Consultation response from KC PROW (footpaths)

2026/90413 land off Enfield Drive, Carlinghow

Permission in principle for erection of one dwelling

Date Responded : 10/3/26

PROPOSED SITE LAYOUT Scale 1:200

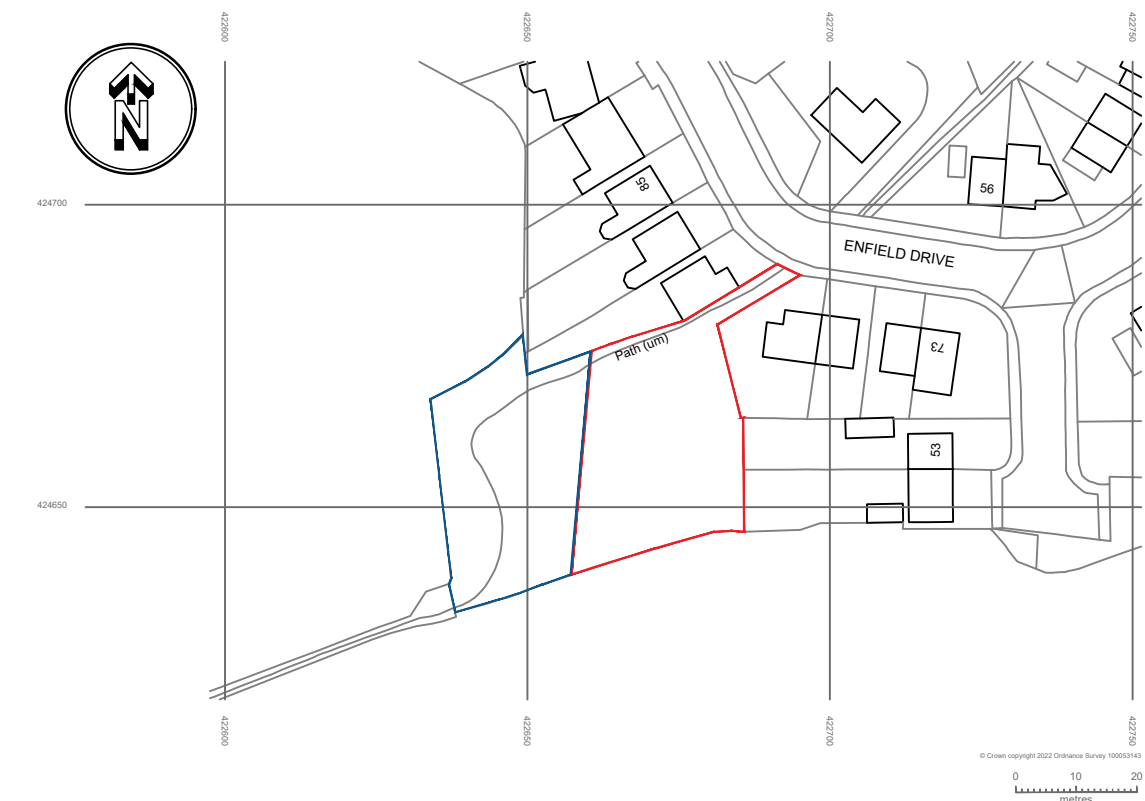
From the information provided Prow would object to the application. The public footpath Batley 23 runs up the access to what would be the drive to the property. The access is narrow and no indication is given on the safety of pedestrians, especially during construction. Further details of how the path is to be incorporated into the development and the protection of the path and its users would need to be provided with any application.

Prow are pleased that the footpath is acknowledged, however we would need additional details of the section where the timber fence separates the garden from the path.

FOOTNOTE Public footpath Batley 23 is the access to and adjacent to the development and must not be interfered with or obstructed, prior to, during or after development works.
